**Summary Of Changes Made Since This Drawing Was Last Issued:**

**1 Hastings Way**

Site: 1 Hastings Way, Bushey WD23 2JX. Job No: 099  
 Drawing No: 099 / SK\_03  
 Title: Informative Plans Revision: B  
 Date: 11/12/2023 Scale: 1:100 @ 100% A3 L

Drawing No: 099 / AP3_03

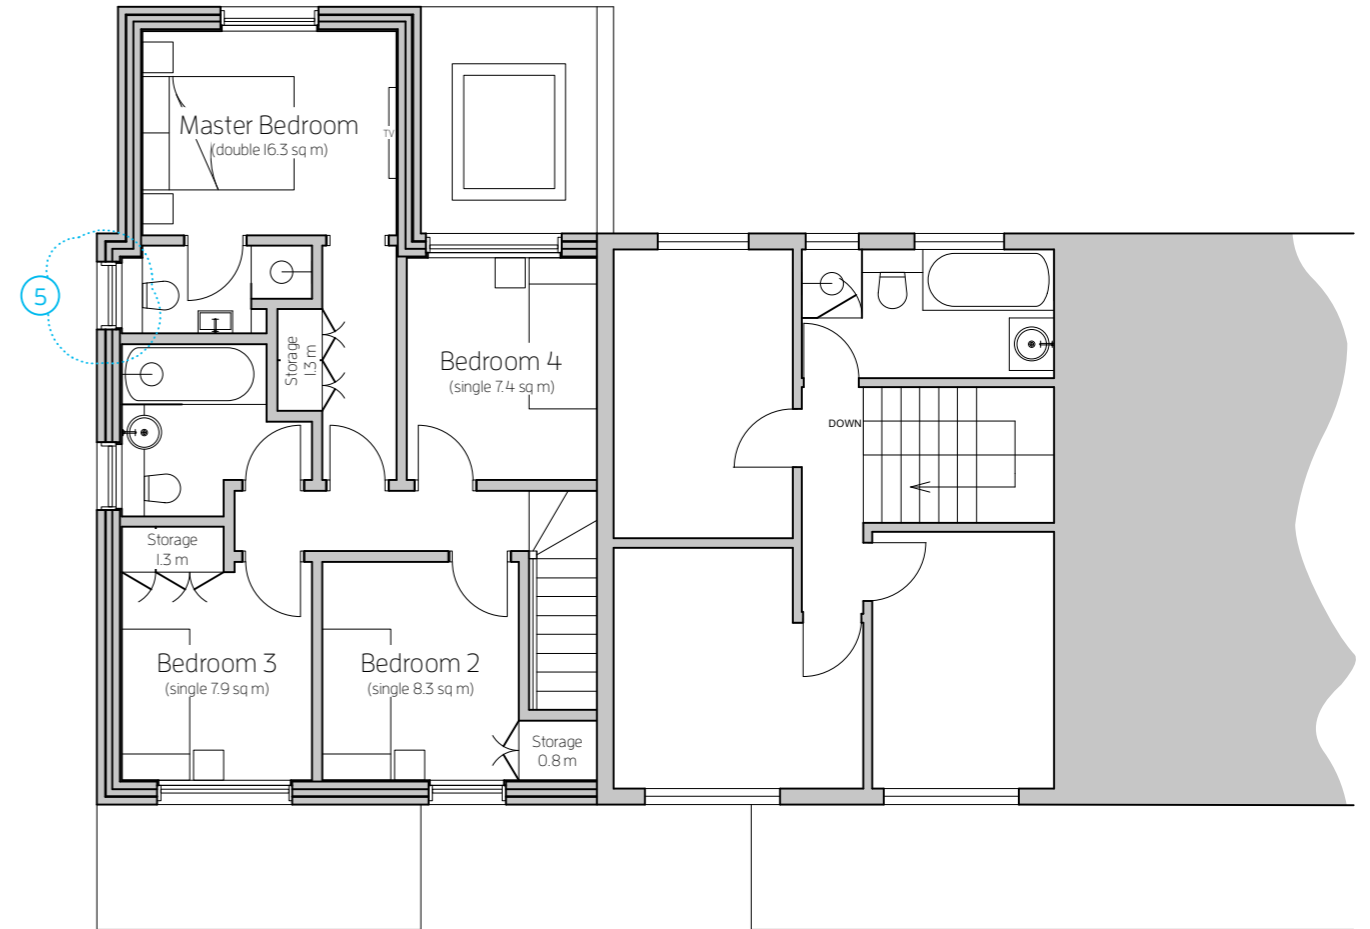
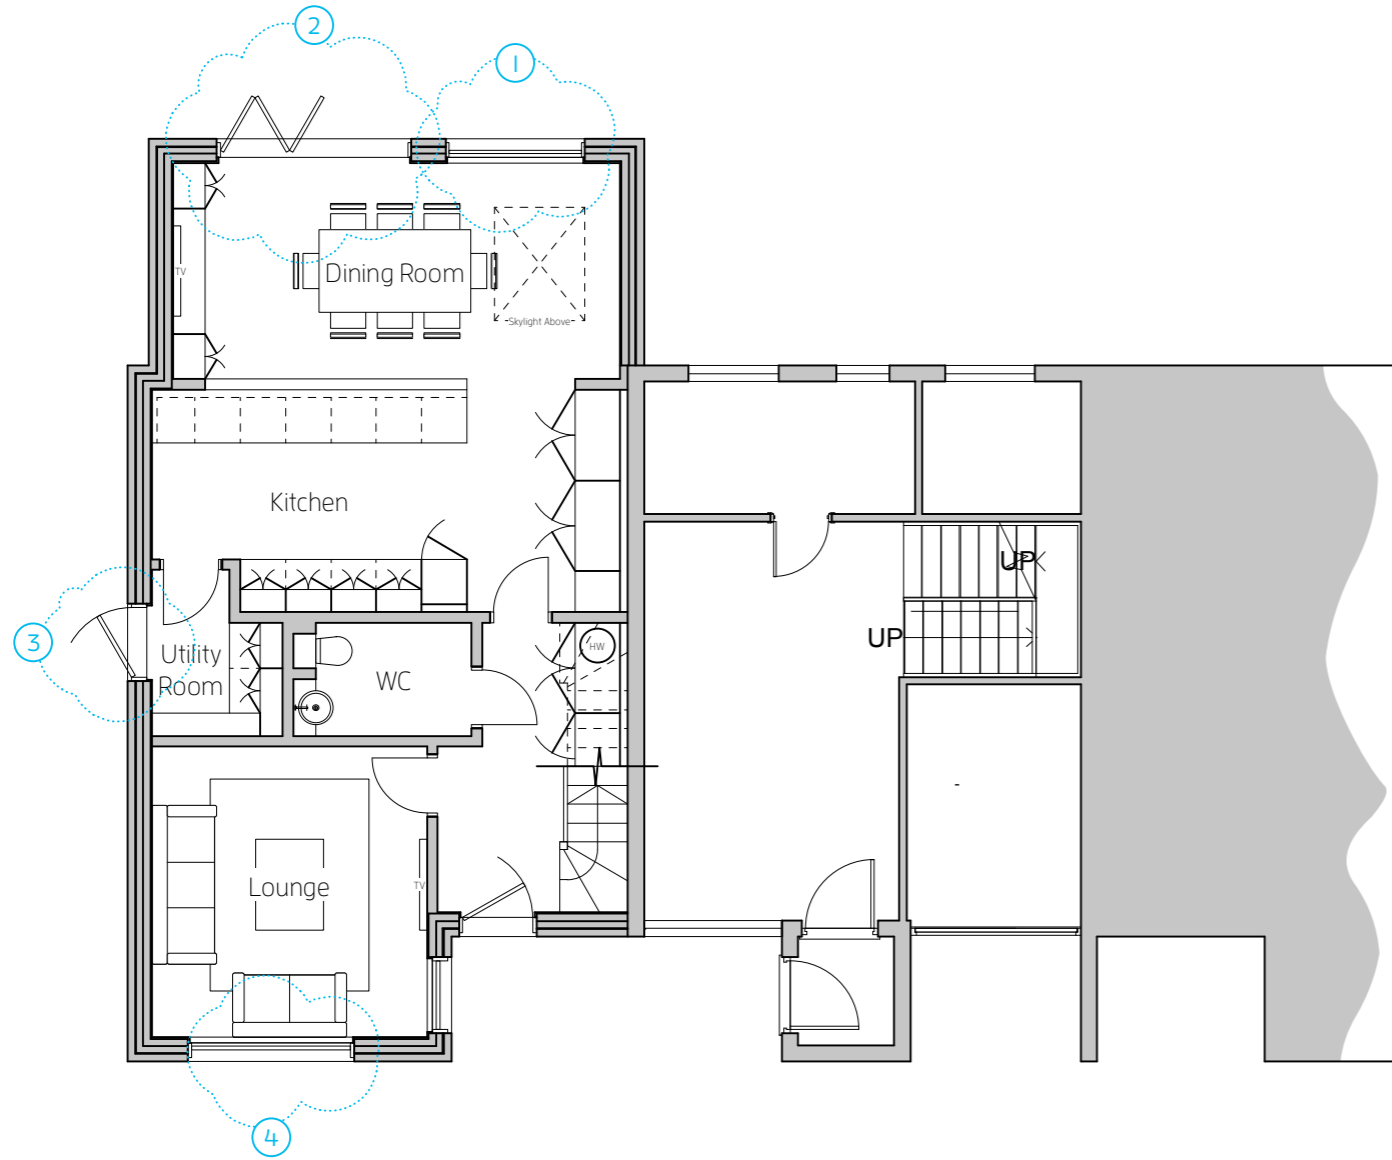
- 1) Structural Opening Now 1845 w / 2160 h. Was 1470 w / 1240 h;
- 2) Structural Opening Now 2575 w / 2160 h. Was 2200 w / 2160 h;
- 3) New Glazed Door With Frosted Finish To Glass;
- 4) Structural Opening Now 2200 w / 1240 h. Was 2030 w / 1240 h;
- 5) New Window With Frosted Finish To Glass;
- 6) Landscape Changes To Provide Side Access.
